Application number: 2023/93206	
What is the application for?:	Erection of single and two storey extensions and raised patio to existing dwelli
Address of the site or building:	4, Dorchester Road, Fixby, Huddersfield, HD2 2JZ
Postcode:	HD2 2JZ

Type of comment: An objection	
Do you wish your comments to be published on the website anonymously?	<input type="checkbox"/> Yes
Re: Application 2023/93206 - Erection of single and two storey extensions and raised patio to existing dwelling and detached garden building.	
<p>Dear case officer,</p> <p>I would like to make some comments regarding this application which I hope will be taken into account when determining the outcome. Unfortunately, there isn't an application form to review on the planning page so I cannot determine whether due consideration has been given to surrounding trees/hedges and the types of material to be used for example.</p> <p>My concerns are two-fold. Firstly, there is very little detail about the floorplan of the proposed annex and indication of what purpose it will serve. The boundaries of this lie less than a metre away from our fence. On the corner of the fence sits a weeping willow which forms the main character

PROPOSED REAR ELEVATION Scale 1:100

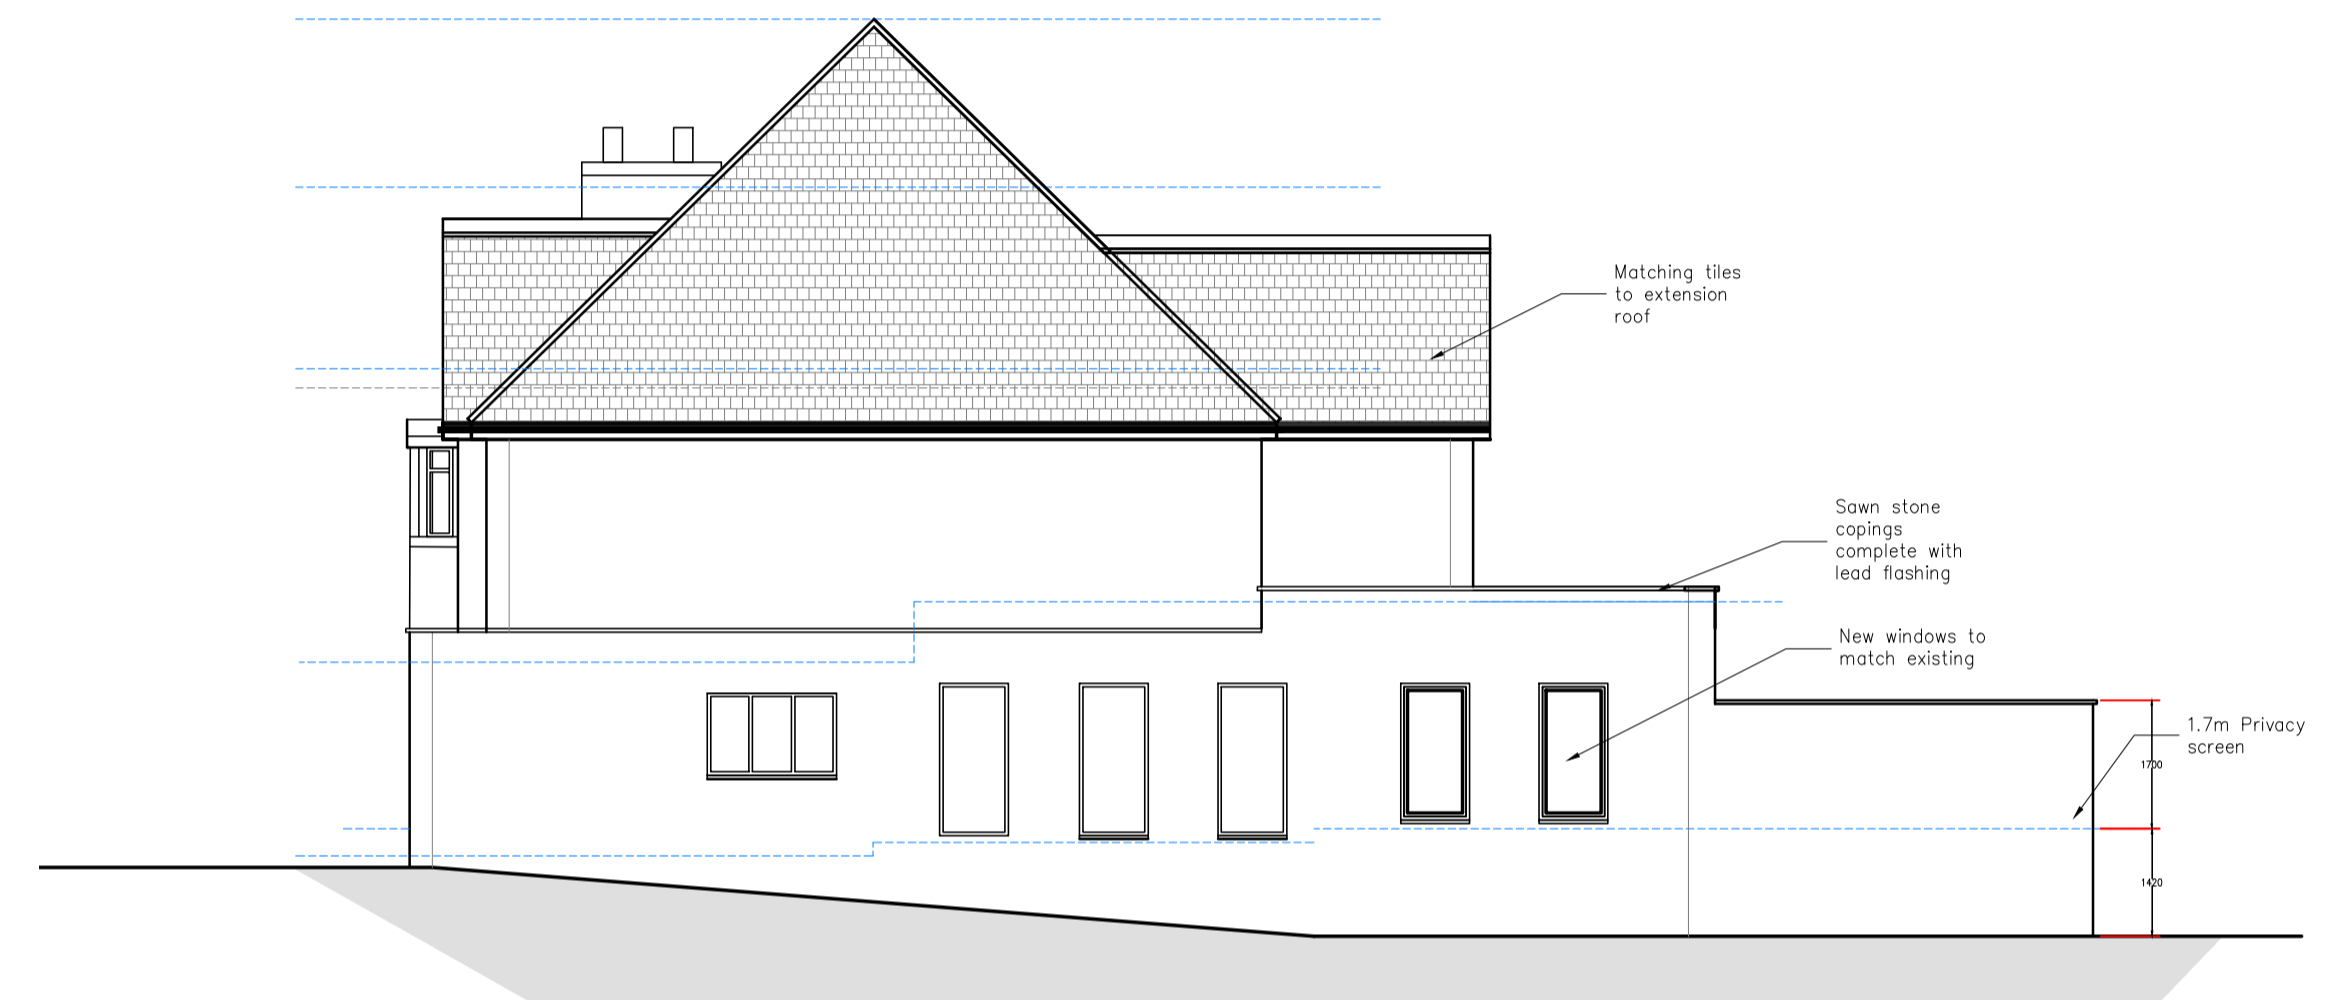
Again, the proposed extension to the back lies very close to our fence where another tree stands (in addition to the willow). I am concerned about whether this could also be damaged in the process of digging the foundations. The previous extension at the back already has windows facing into our garden impeding privacy. A further extension to the back will add further to the view of our garden from 4 Dorchester Road. See figures 1, 2, 3 & 4.
